Your Ref :
Our Ref : P/119/13/NMA

Section 96A of the Town & Country Planning Act 1990 (as amended)
Town and Country Planning (Development Management Procedure) (England) Order 2010 (as amended) - Article 9

Application for a non-material amendment following a grant of planning permission P/76/13/ to change 1 No window shape from round to rectangular, lowering of 1 No window sill height and the addition of 2 No velux windows on roof west side for additional light into main living space.
46 Lagoon Road, Pagham, ,

South West Elevation

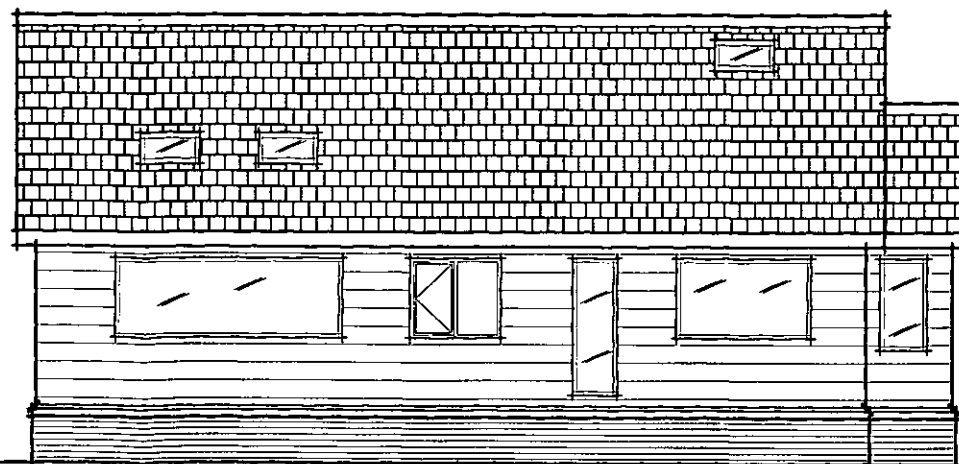
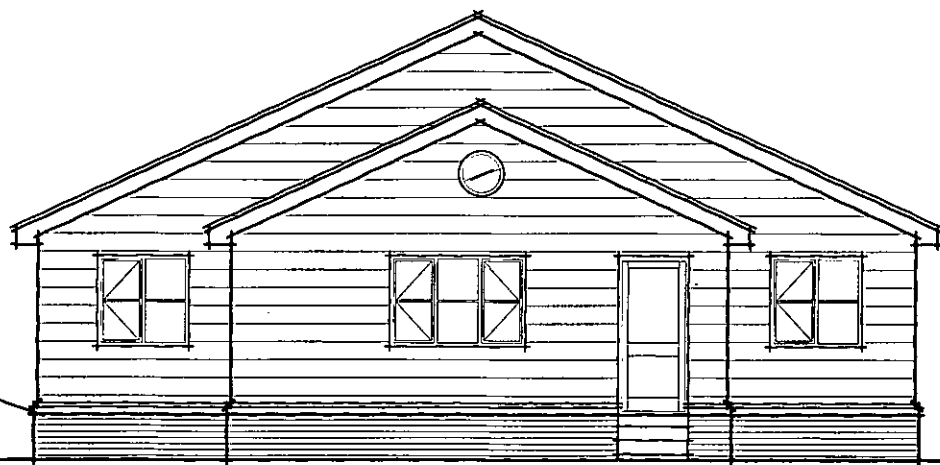
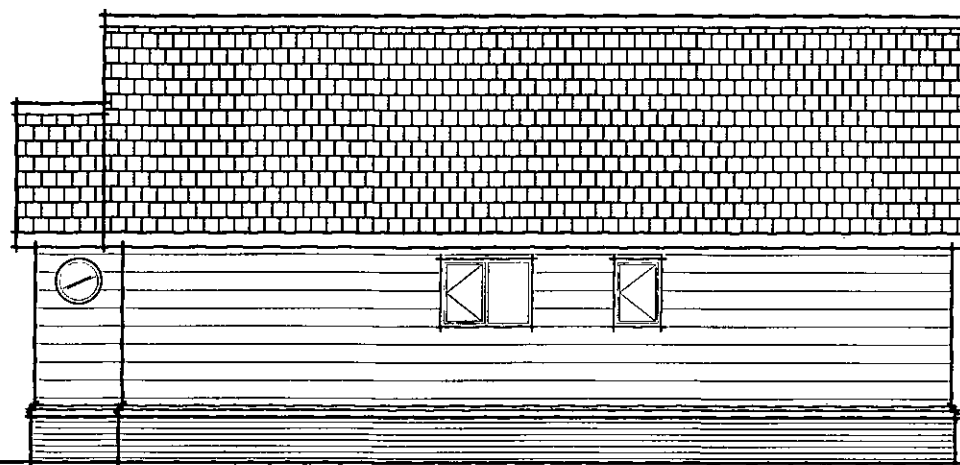
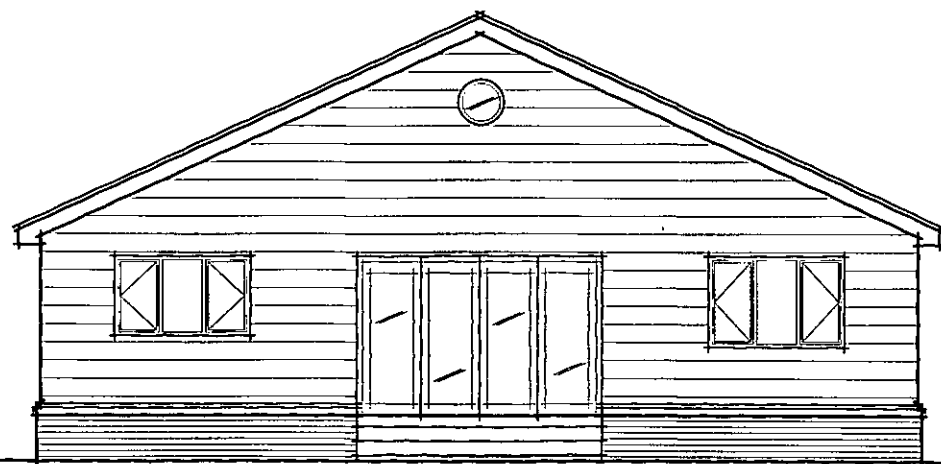
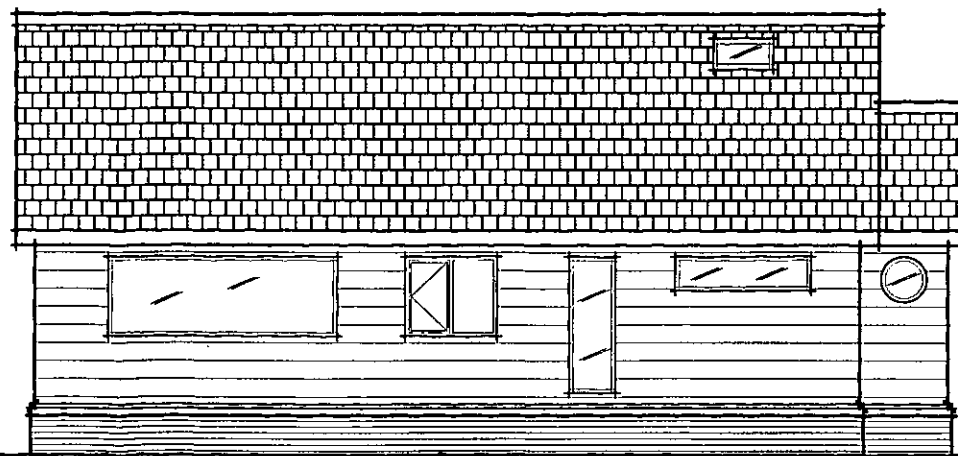
The alteration of the window from round to rectangular, increase in window size, addition of two rooflights (3 in total) on the south west elevation can be accepted as a non material amendment. The submitted Drg No 81269/BR04 dated November 2013 now becomes the approved plan for planning application P/76/13.
